CITY OF PORTLAND

BUILDING PERMIT

Job ID: 2011-10-2418-ALTR

has permission to Rebuild a demolished 16 by 19 foot section (within existing footprint).

WALL SECTION 2: DECKING AT EXTERIOR WALL  
SCALE: 1/2" = 1'-0"

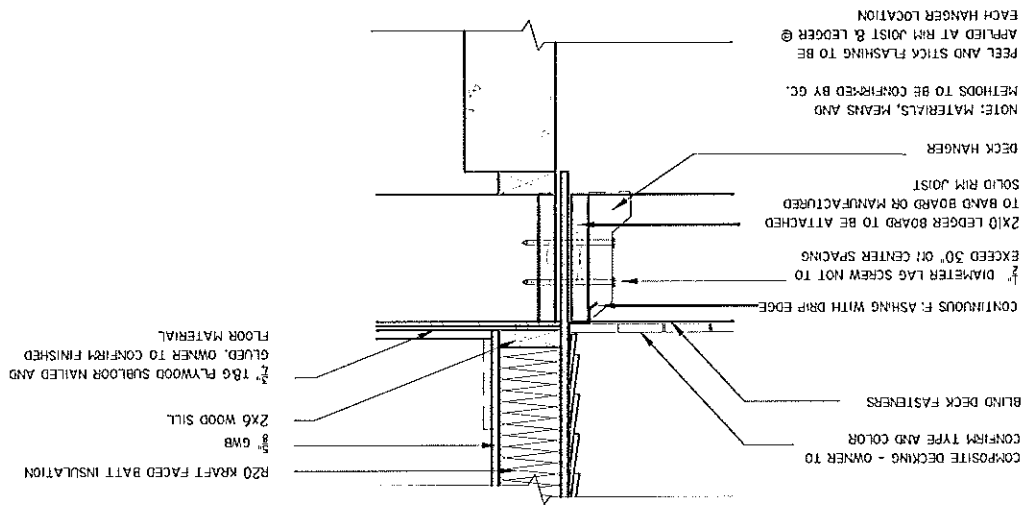
7. R311.5.1 Attachment. Exterior landings, decks, balconies, stairs and similar facilities shall be positively anchored to the primary structure to resist both vertical and lateral forces or shall be designed to be self-supporting. Attachment shall not be accomplished by use of toenails or nails subject to withdrawal.

DETAIL: DECK FOUNDATION  
SCALE: 1" = 1'-0"

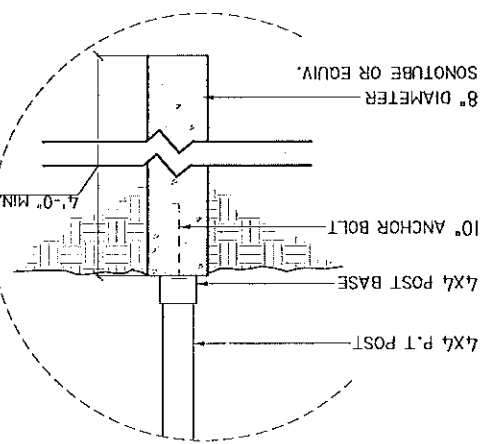
9. Ventilation/Access for the new section of the foundation (crawl space) shall comply with Section R408.1 & R408.3.
10. Note: Contractor stated the Structural Ridge will be posted-down to foundation were it meets the existing house; the Foundation/ Retaining wall will comply with Section R404. Double 2 X 10" SPF # 2 Beams will be utilized with a max span of 7'-3" for the deck.

DETAIL: DECK STAIR & RAILING  
SCALE: 1/2" = 1'-0"

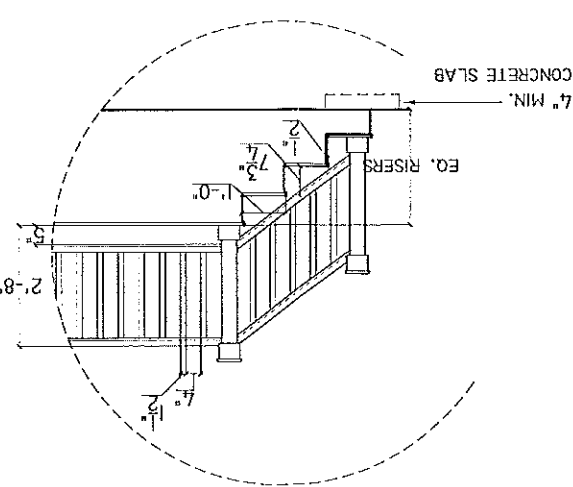
4. A graspable handrail (34-38 inches in height) shall be provided on at least one side of each continuous run of treads or flight with four or more risers. **Fall protection (36 inches) from exterior decks may be required if floor joist are at or above thirty (30) inches from grade.**
